# CITY OF ALBUQUERQUE

**Re: Circle K Store – Albuquerque, NM** (10850 Golf Course Rd. NW)  
Engineer's Stamp dated January 3, 2022 (A12D008B1)  
Received 1/3/2022  
CABQ Planning Transportation comments

The subject Traffic Impact Study for the Circle K Store – Albuquerque, NM (10850 Golf Course Rd. NW) dated January 3, 2022 has been reviewed by the City's Transportation Development Section. The following should be addressed in the next submittal.

C1

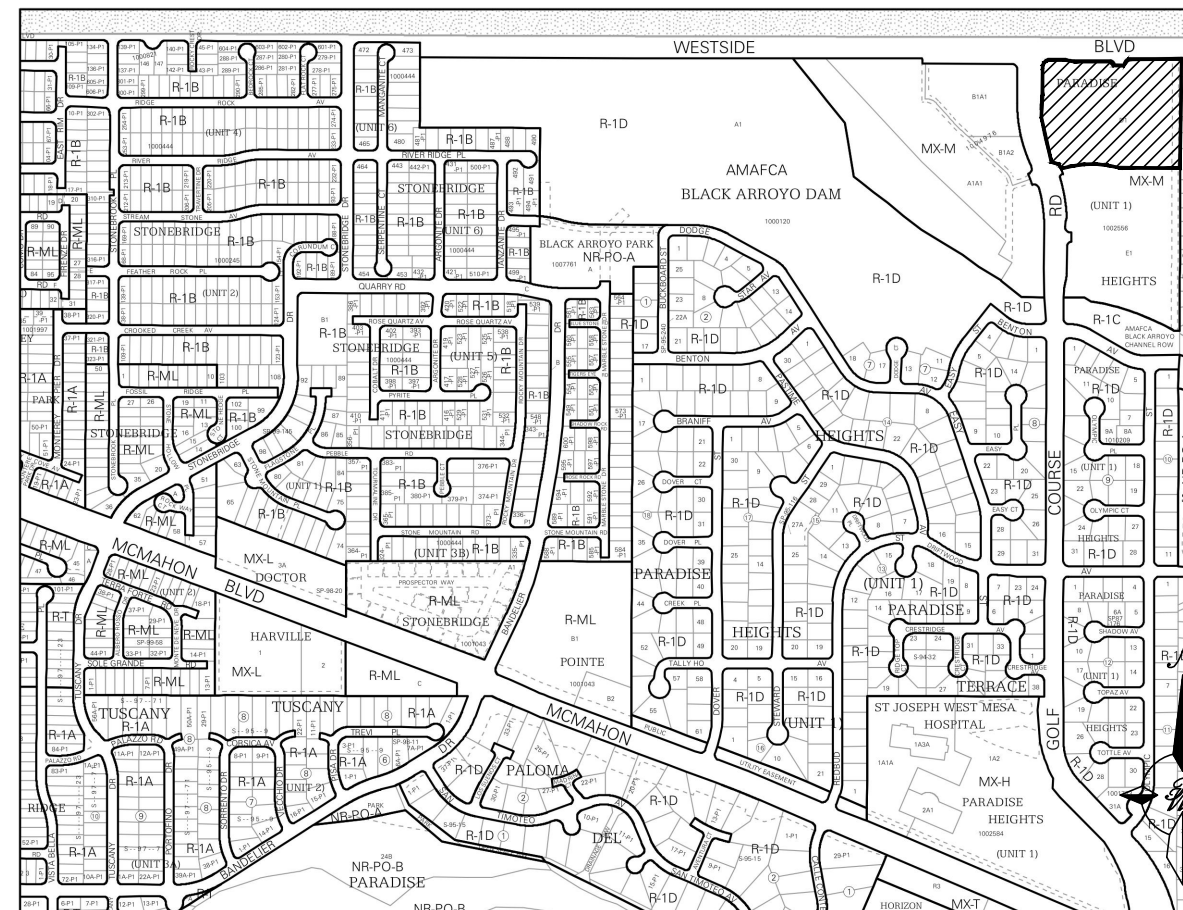
1. The developer shall coordinate site plan development and roadway design with COA project CPN 589493, contact Tierra West, LLC.
2. Driveway "A" northbound right-turn lane length is limited due to the location of the proposed driveway to the south, reference COA project CPN 589493. The distance between the driveways is ~200 feet. The City will allow this turn lane to be shortened in length to fit the geometric constraints. The developer is to provide graphical evidence for the reduced turn lane length.
3. Developer to coordinate with COA Transit due to the existing bus stop on Golf Course Rd near driveway 'A'.

4. Driveway "B" eastbound right-turn lane length is limited due to the distance the driveway is from the Golf Course Rd. intersection. The feasible length of the right-turn lane is approximately 275 to 300 feet. The City will allow this turn lane to be shortened in length to fit the geometric constraints. The developer is to provide graphical evidence for the reduced turn lane length.
5. HCM Results Summary table on page iv; the Movement column shows Irving Blvd. This should be Golf Course Rd.
6. HCM Results Summary table on page V; the Movement column shows Irving Blvd. This should be Golf Course Rd.
